**Re: Response to Submissions - Environmental Impact Statement, Sirius  
Development 2-60 Cumberland Street, The Rocks – SSD 10384  
LOC Reference Number: #11059**

Place Management NSW have reviewed the Environmental Impact (EIS) for the Response to Submission and provide the following comments.

DWG. TITLE  
**Landscape Plan - LEVEL 09-11**  
 PROJECT  
**SIRIUS SITE, 2-60 CUMBERLAND ST, THE ROCKS**

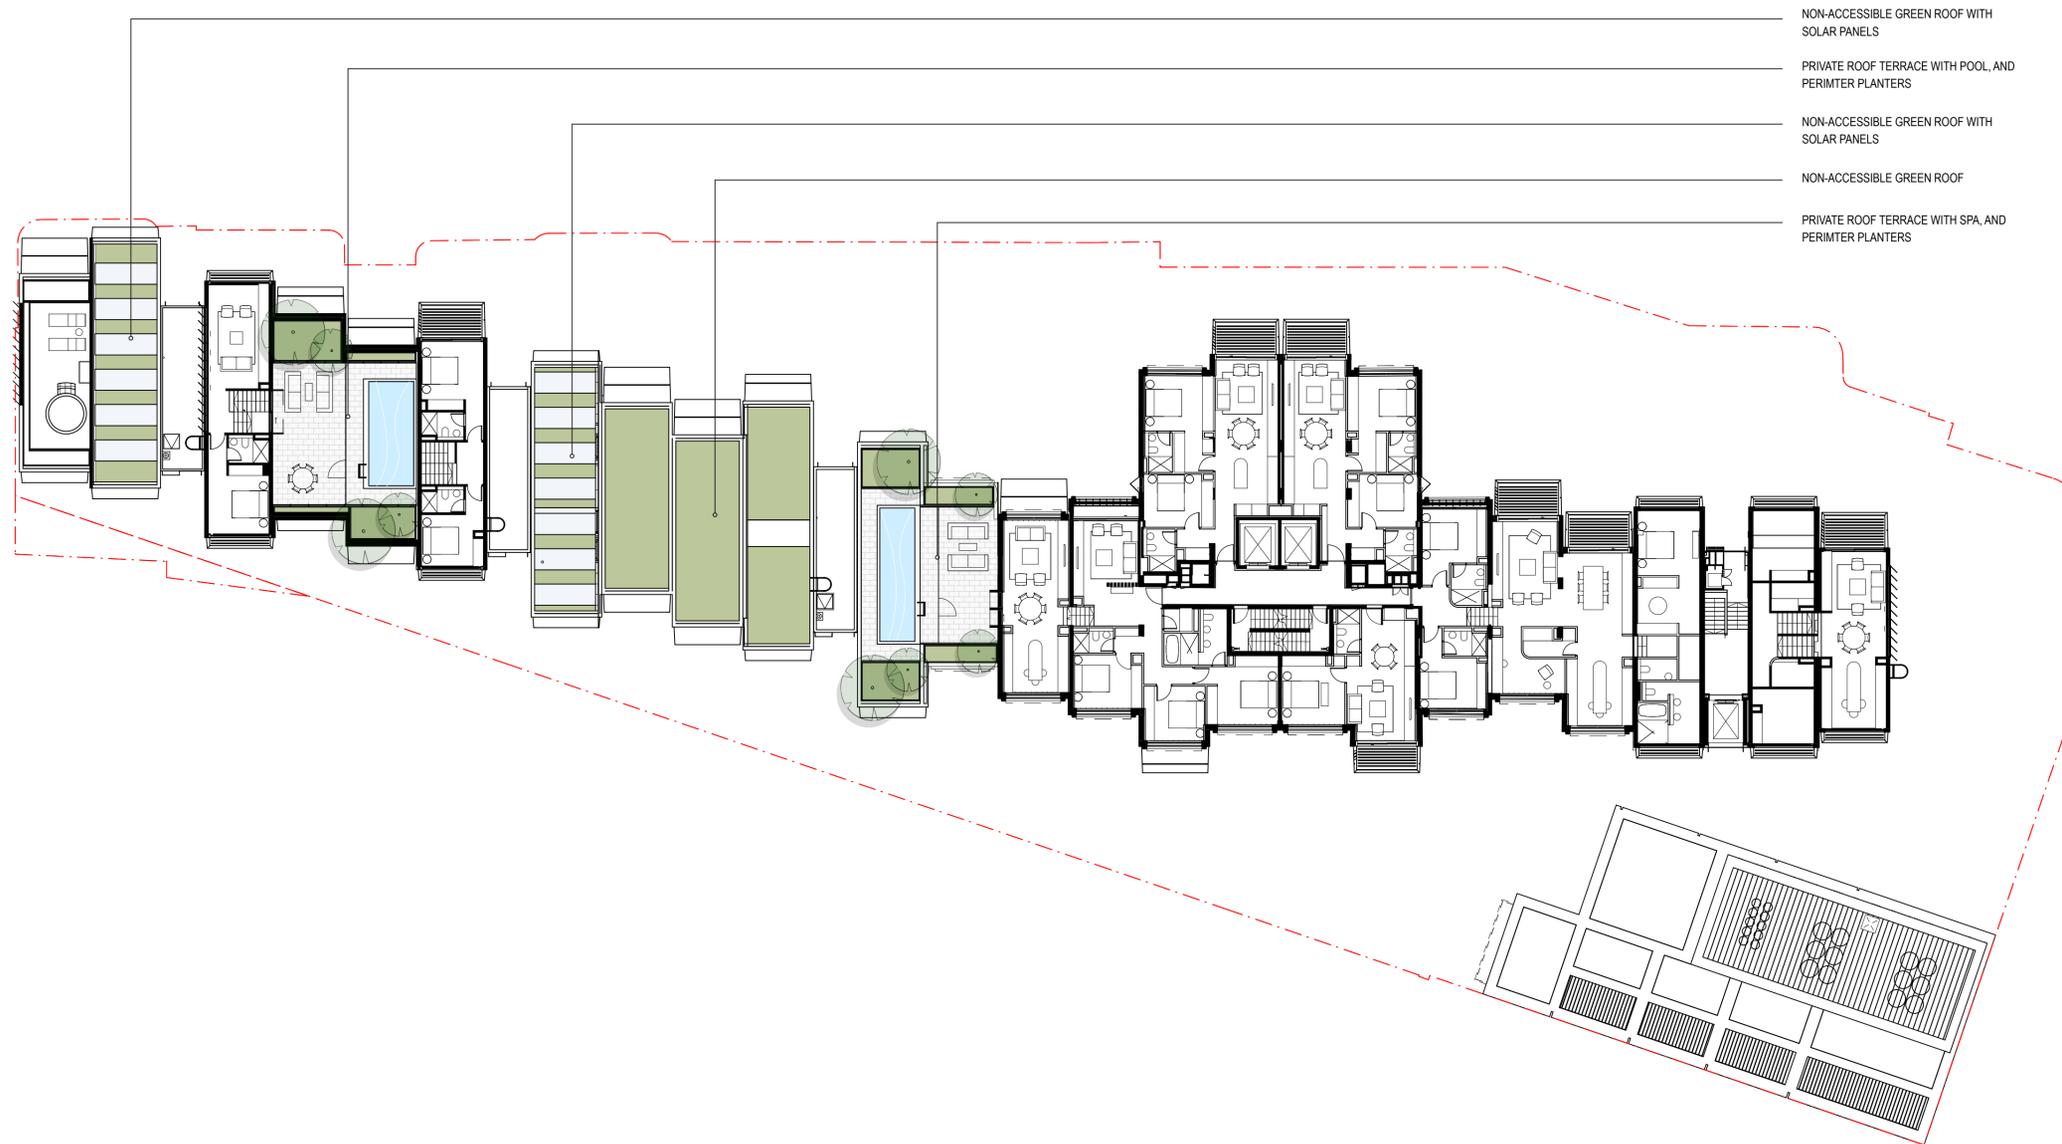
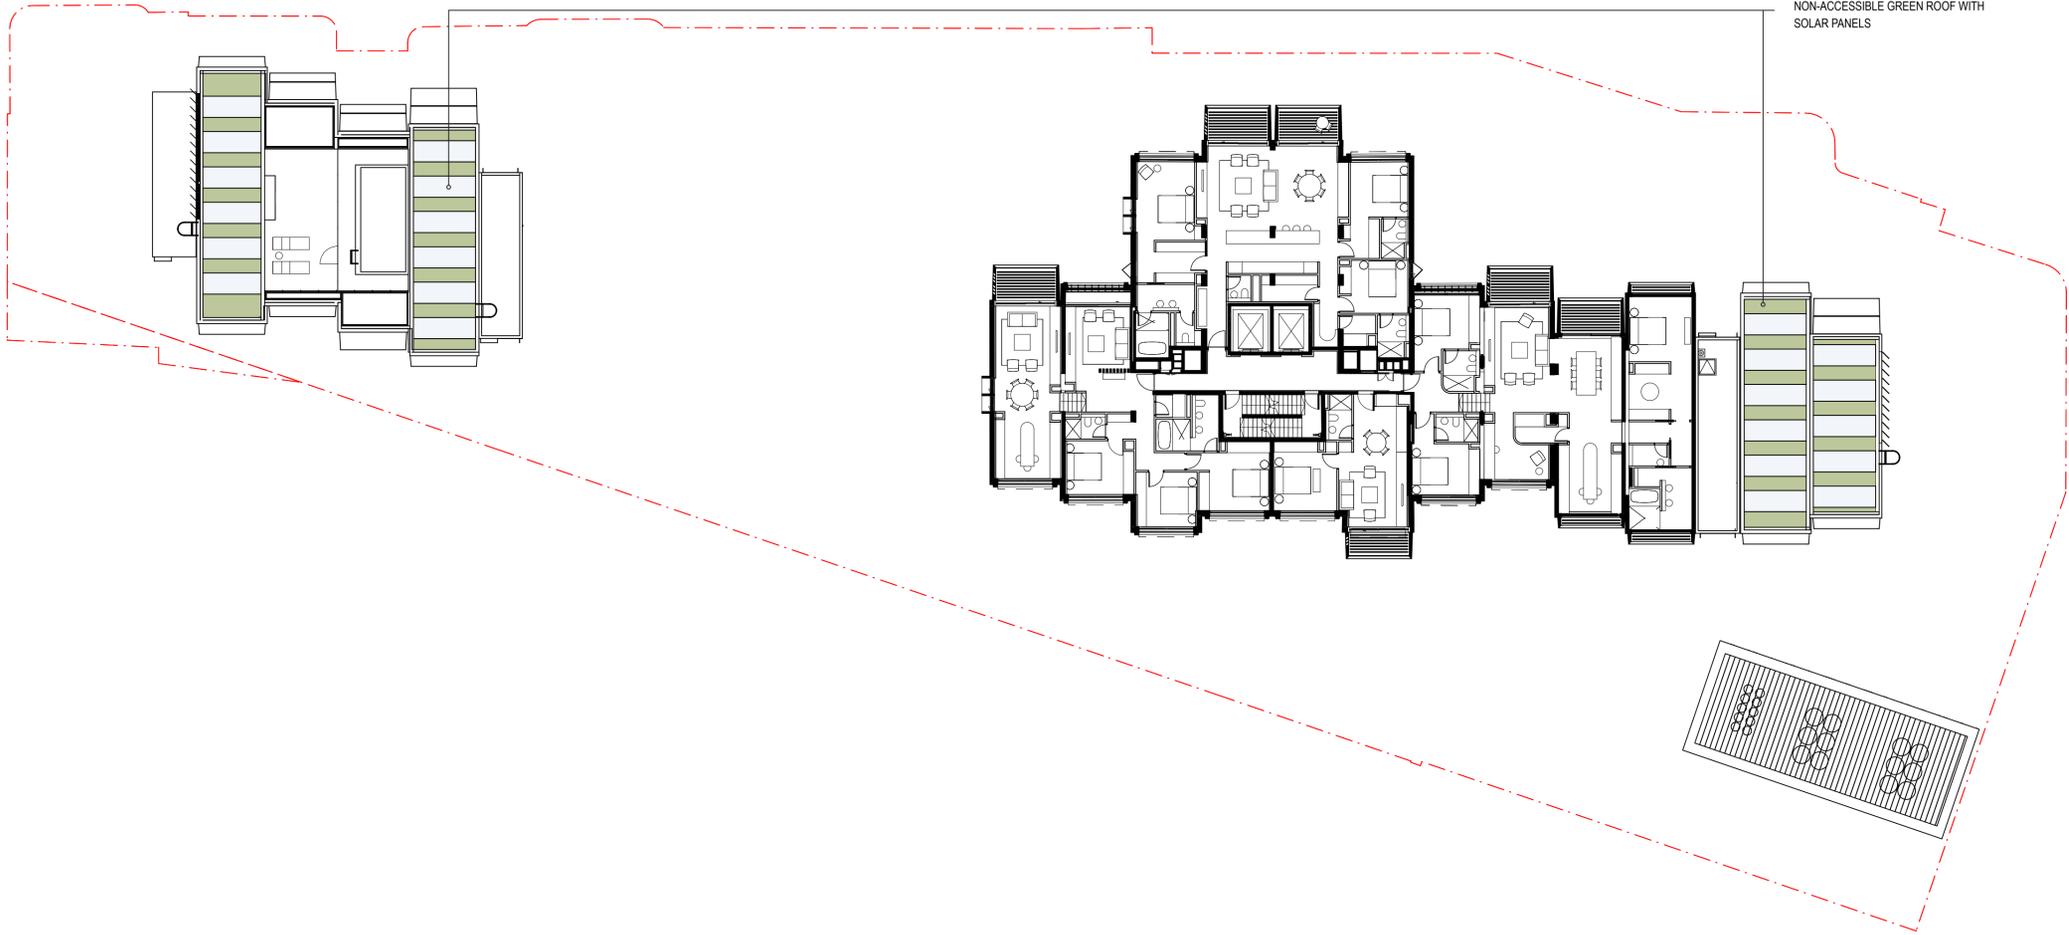
- Signage & wayfinding to be shall subject to further development, consultation, review and approval by PMNSW.
- A detailed landscaping plan showing the proposed plant selection shall be submitted to PMNSW for review and approval prior to the issue of final LOC or CC. The plan shall also consider how the proposed plant selection contributes to enhancing the natural heritage of The Rocks.

NORTHERN POCKET PARK

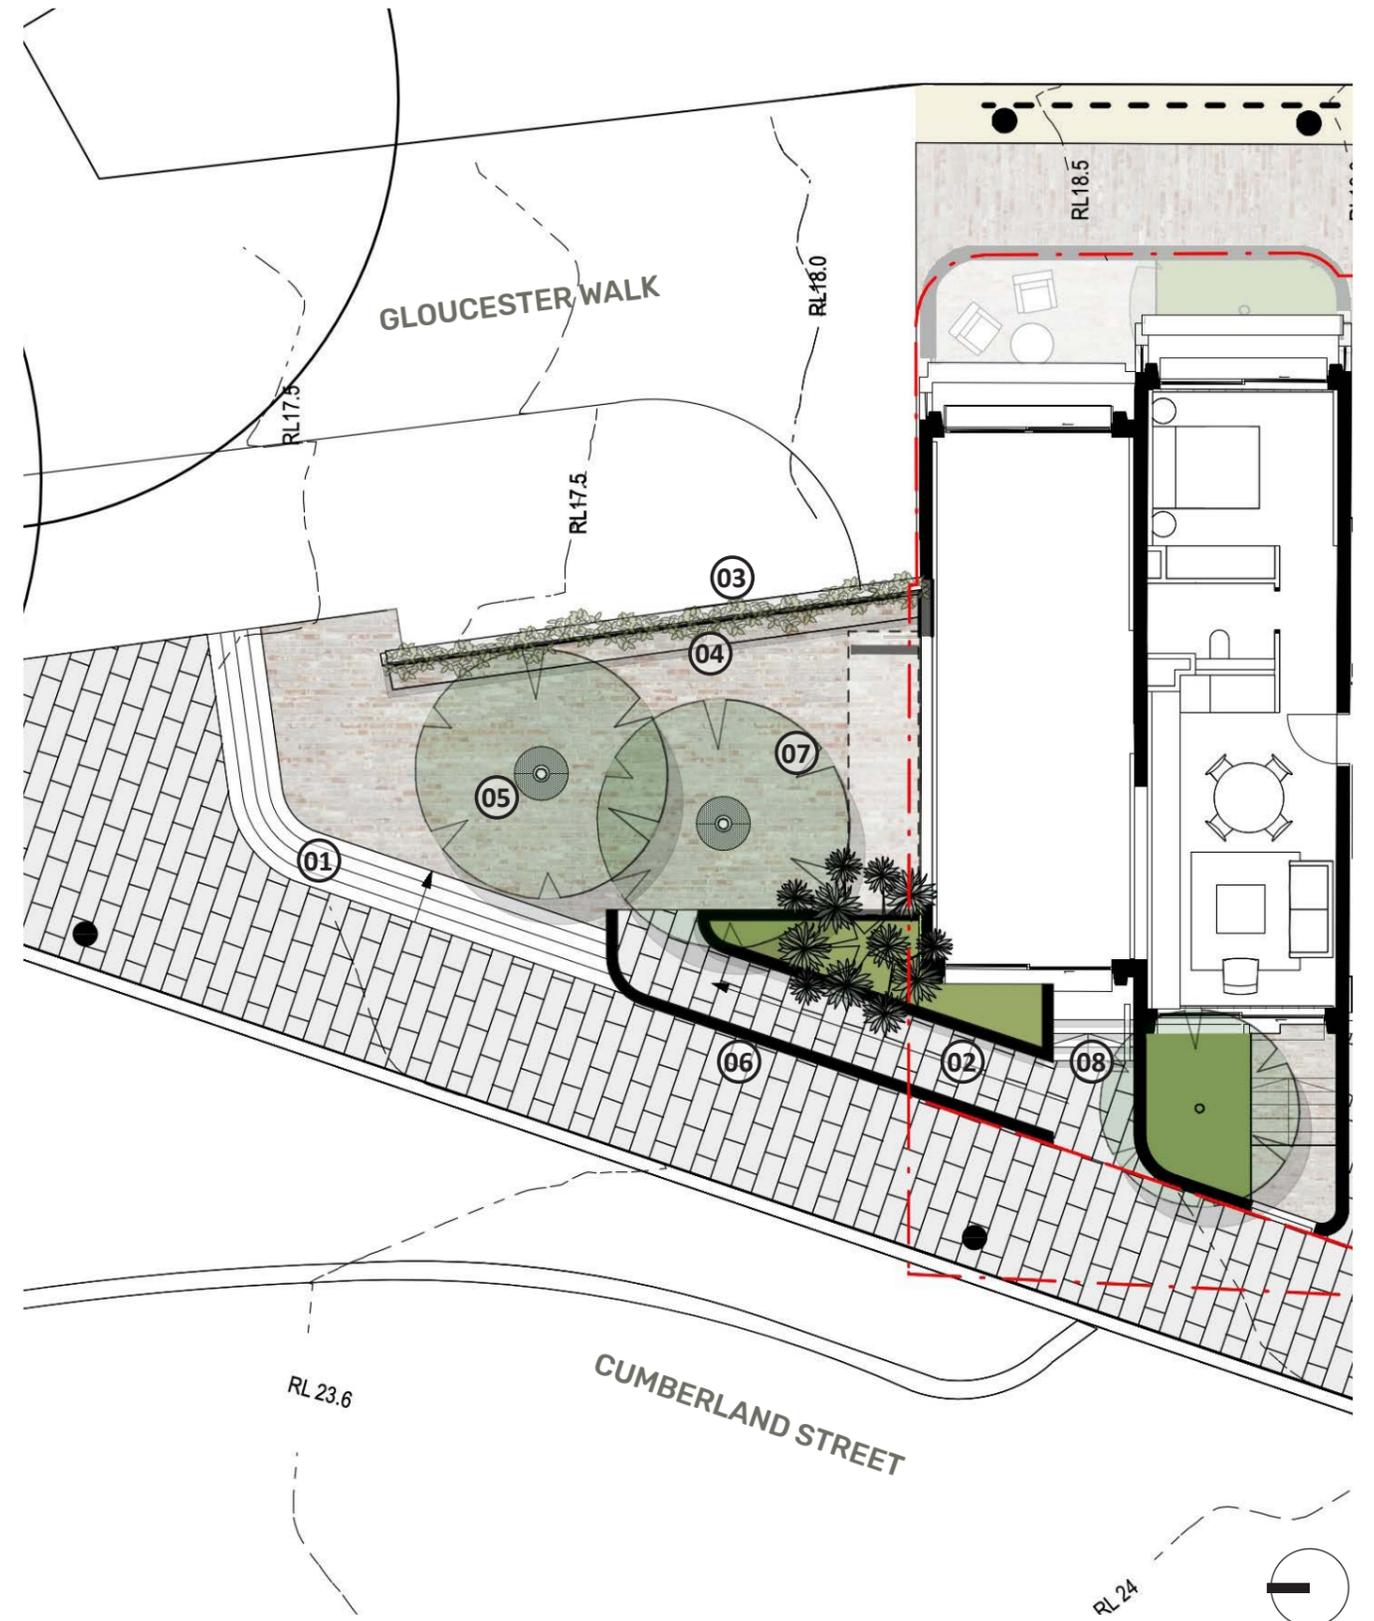
- Additional information is to be provided in relation to the design of the Park upgrade to the northern end of the Sirius development including further heritage impact assessment for the impact of the works on 23 George Street.

- The detailed design of the park is to be carried out in consultation with PMNSW and be provided for approval prior to issue of a CC.
- The detailed design of Gloucester Walk to include grading adjustments and public seating, bins and design interface with the Sirius Building in consultation with PMNSW prior to the issue of a CC.

- PMNSW does not support the use of the proposed pocket park (on top of Ajax building) as a playground.
- Retail would be preferred for tenancy bordering the pocket park and this is currently noted in the landscape report to have outdoor dining. If the usage changes to other commercial, there is a requirement to activate beyond the building line with seating.
